From: Simon Davis
Sent: 17 February 2021 16:45
To: Planning Scanning
Subject: FW: 23018 - Planning Consultation on: Y/148/20/DOC

Condition 12- surface water drainage design

Application No: Y/148/20/DOC

Site Address: Bonhams Field Main Road Yapton BN18 0DX

- GENERAL NOTES:**
1. All dimensions to be checked on site. All details and dimensions relating to sub-Contractors work must be checked and agreed between the sub-Contractor or supplier and the general Contractor.

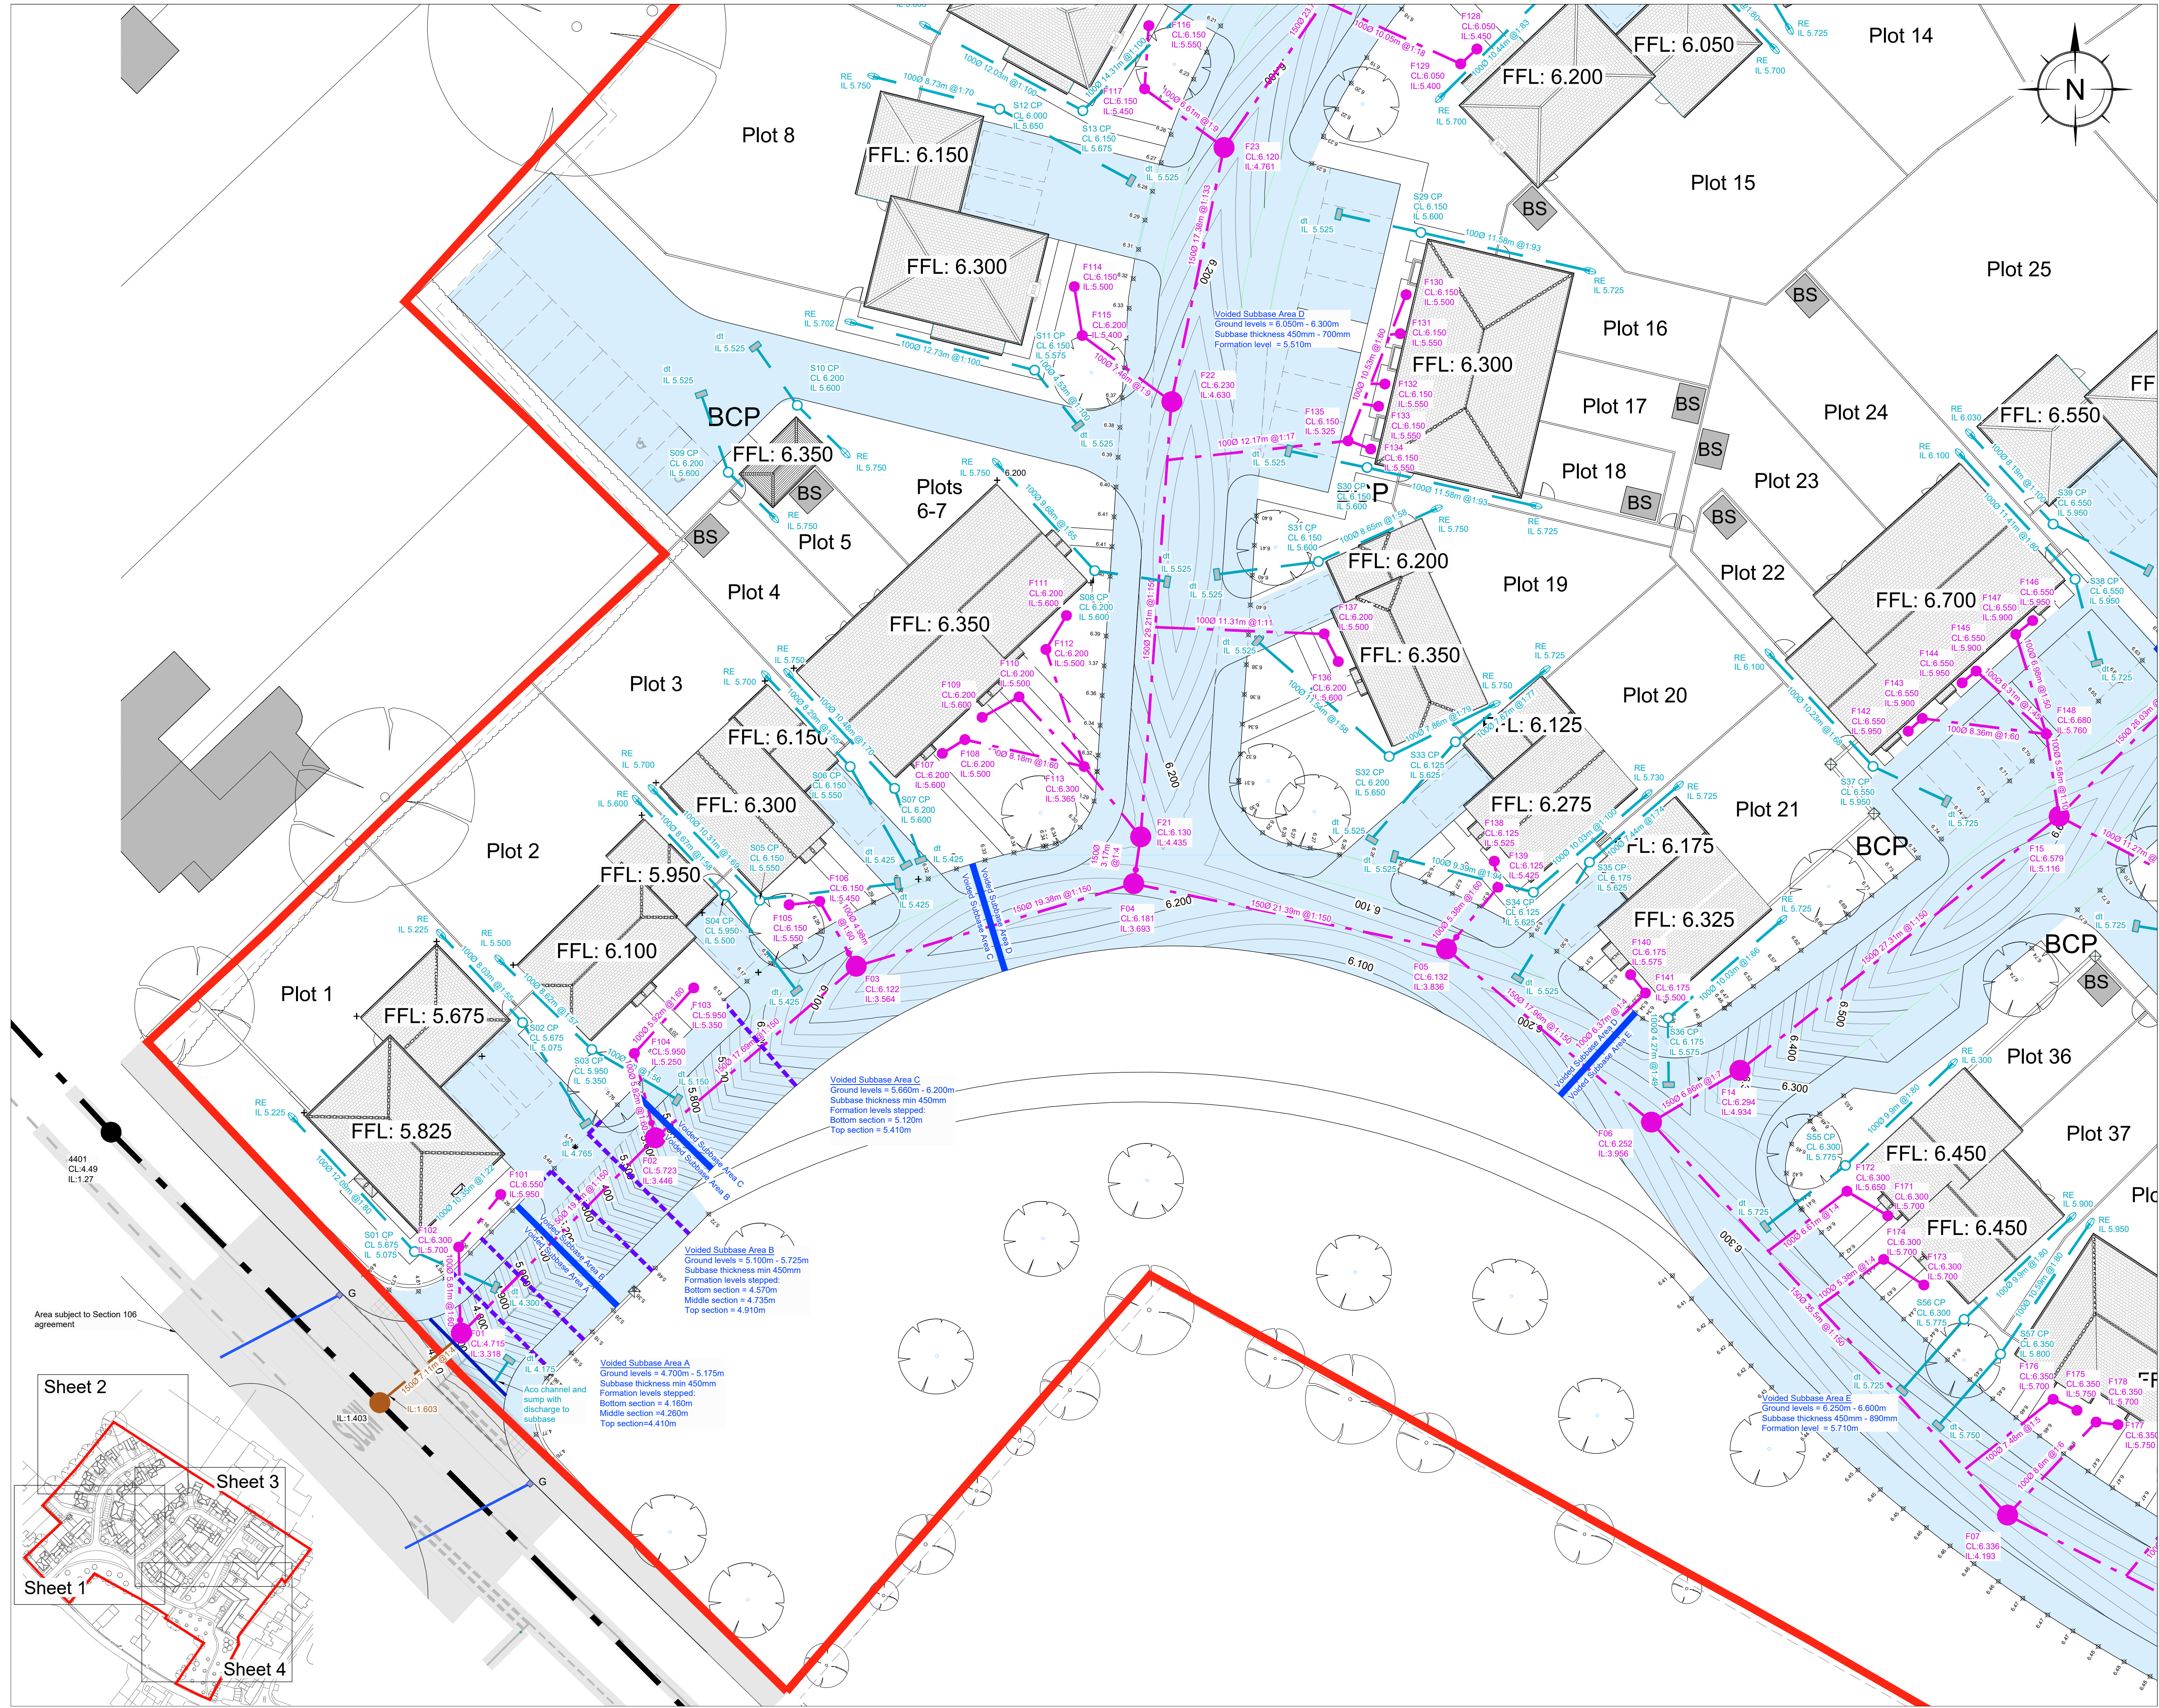
4. A factor of safety of 2 has been used throughout. This is low. We would like to see a factor of safety of 4 applied to catchment areas greater than 1000m². We see this as a substantial compromise upon the table contained within our checklist.

Following our discussions we have updated all calculations to include a Factor of Safety of 4 and updated subbase depth accordingly. This has increased subbase depth by a maximum of 70mm, which is in Catchment H. As discussed the half drain time for the 1 in 100 plus 40% storm event is increased to almost 33 hours which was agreed as acceptable during our recent meeting. The drawings have been updated to reflect this change. *This is not an entirely accurate representation of our discussions. Features must half drain within 24 hours for the 1 in 10 year plus 40% cc event, as detailed this is the absolute minimum requirement and can be applied instead of the 100 year plus cc event when agreed by the local engineer. Please supply half drain times for the 1 in 10 year plus cc event for all features where half drain time exceeds 24 hours for the 1 in 100 year plus cc event.*

Catchment F has a FOS of 2 applied in calculations.

5. I note that in areas G and H you are proposing to locally deepen the sub-base around diffusers. Inlets should be set above the 1 in 10 year plus 40% cc event water level, they certainly should not be set below the base. Please reconsider the design here and check all areas have inlets set above the 1 in 10 year plus 40% climate change water level.

I note that pipe falls of 150 diameter pipes are at 1:167, this is below the gradient required to achieve 1m/s self-cleansing velocity. Please ensure all pipes achieve minimum falls.
